AB/86/19/HH & AB/87/19/L

These comments relate to the revised plans submitted on the 24 September 2019.

This application relates to a single storey rear extension, new deck area, external staircase, removal of hanging tiles at first floor level and infilling a covered walkway area.

PROPOSED PLAN - GROUND FLOOR

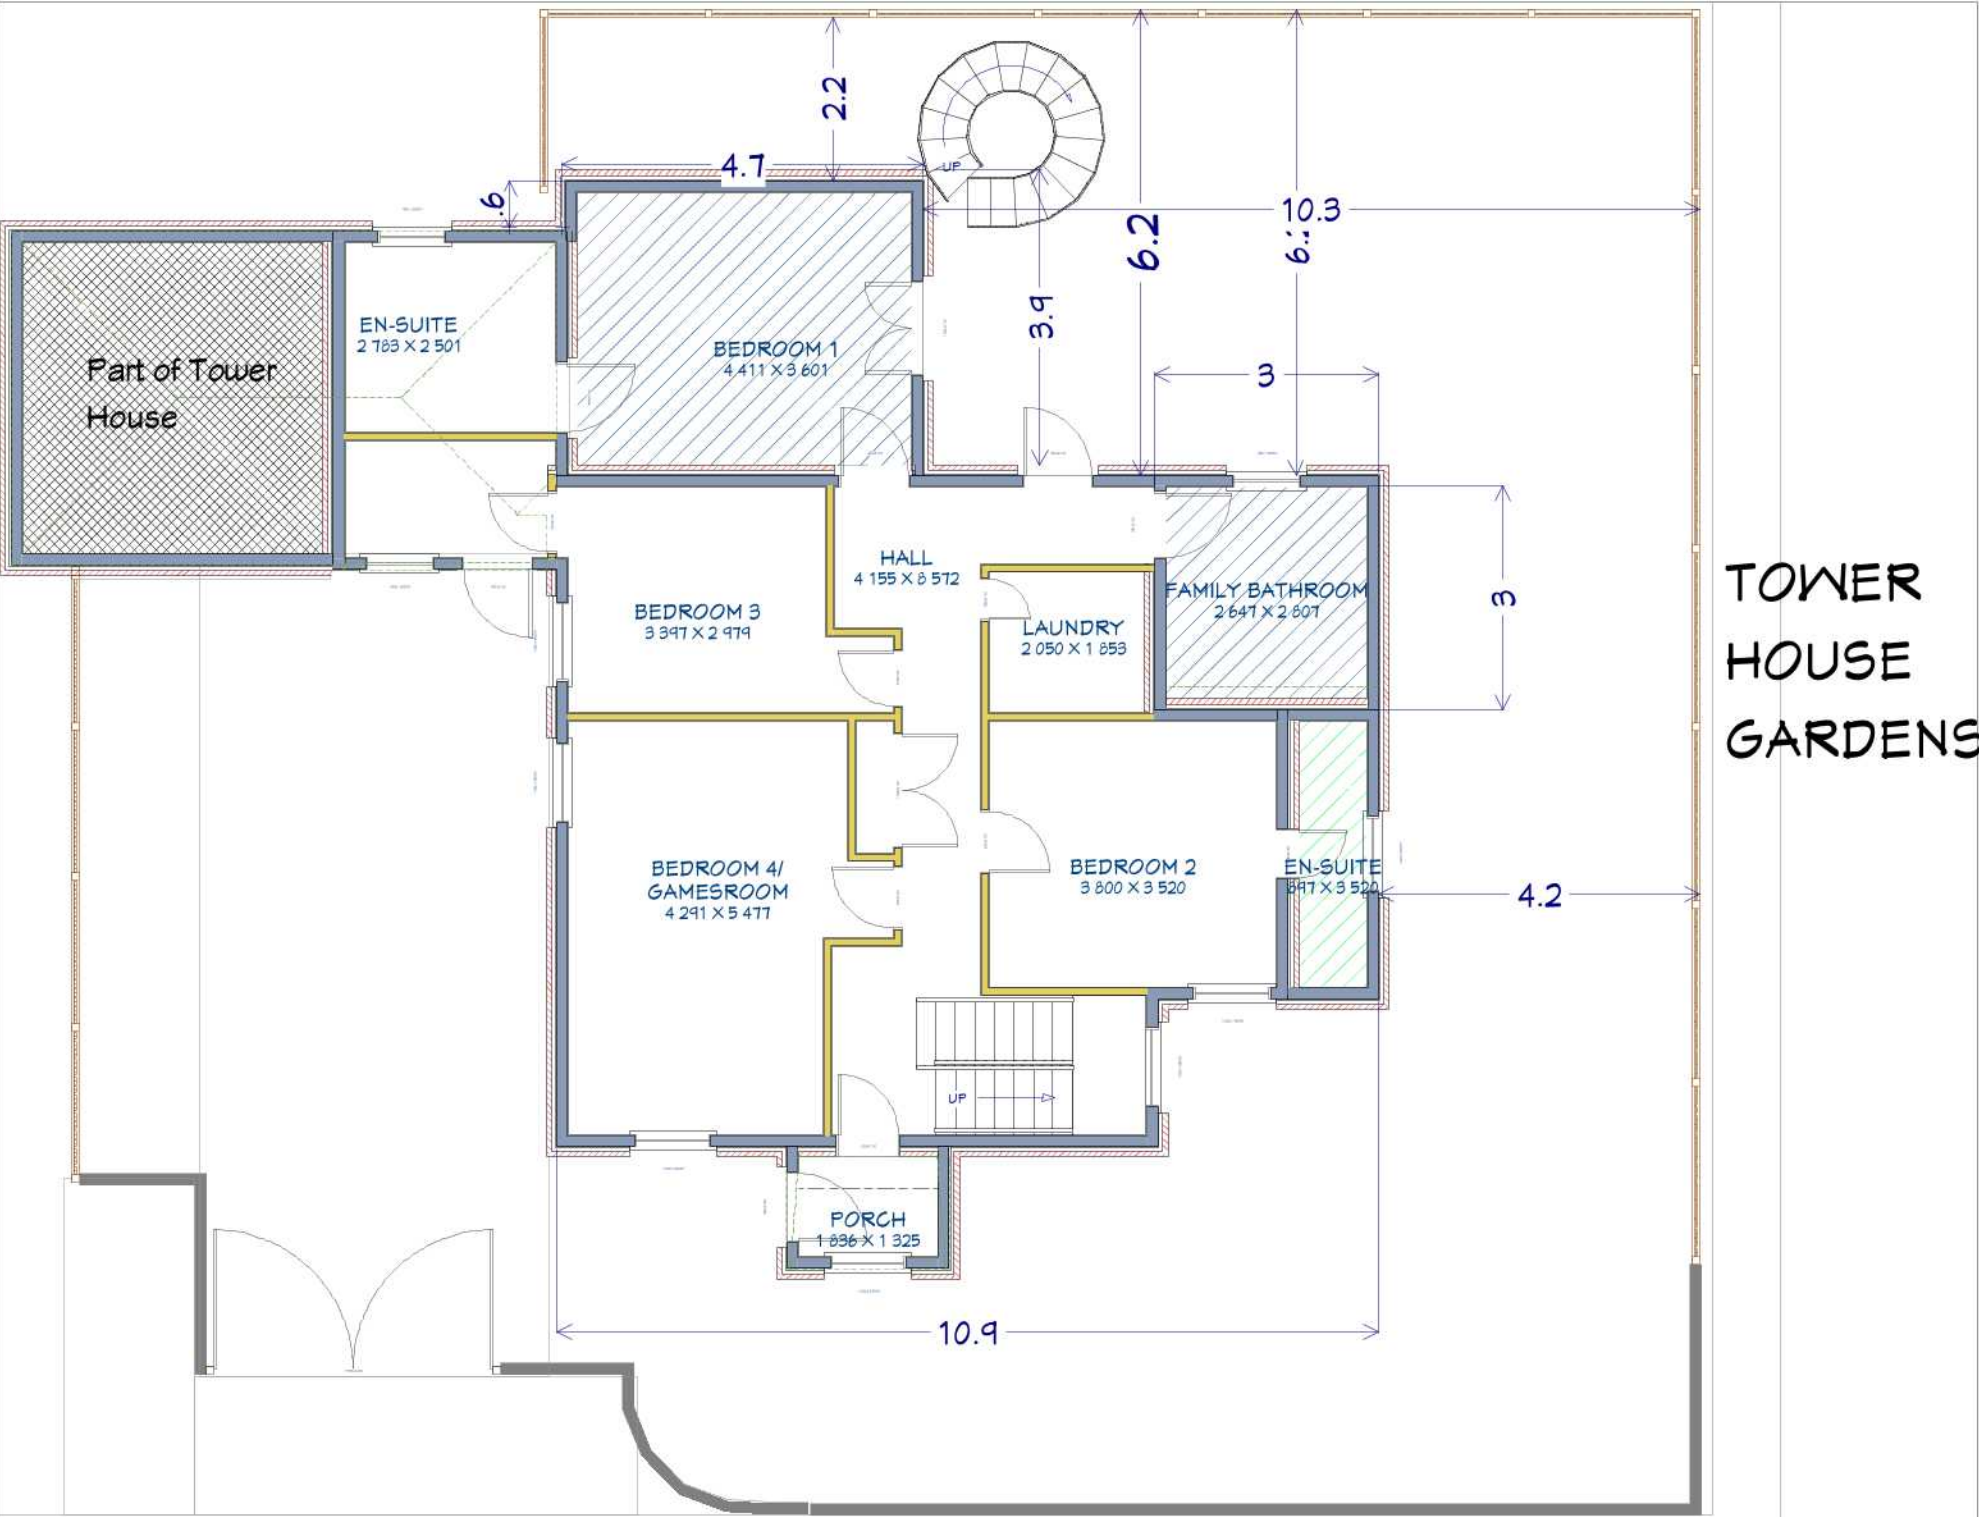
The concept of extending the property is considered to be acceptable, if it is undertaken in a sympathetic manner. Having had the opportunity to review the plans, it is considered that the single storey extension is of a scale that it will have a neutral impact upon the host dwelling. Further, its location is such that it will not have a significant impact upon the street-scene. This comment is made subject to the use of appropriate materials and railings.

It is also considered that enclosing the covered walkway area will not detract from the character of the building or area. This is subject to the brick to be used. The elevations provided for this element partially screen the proposed elevation through the presence of the boundary treatment.

Whilst the concept of replacing a door with a window at the western elevation of the building linking the Mews House and Tower House is acceptable, I cannot see any details/elevations of what this will look like. Will the window occupy all or part of the space currently occupied by the door? At present the elevations do not appear to show this

- Details of the brick/brick bond in order to ensure that it matches the existing
- Details of the railings and stairs
- Joinery to match existing
- Details of the proposed southern elevation
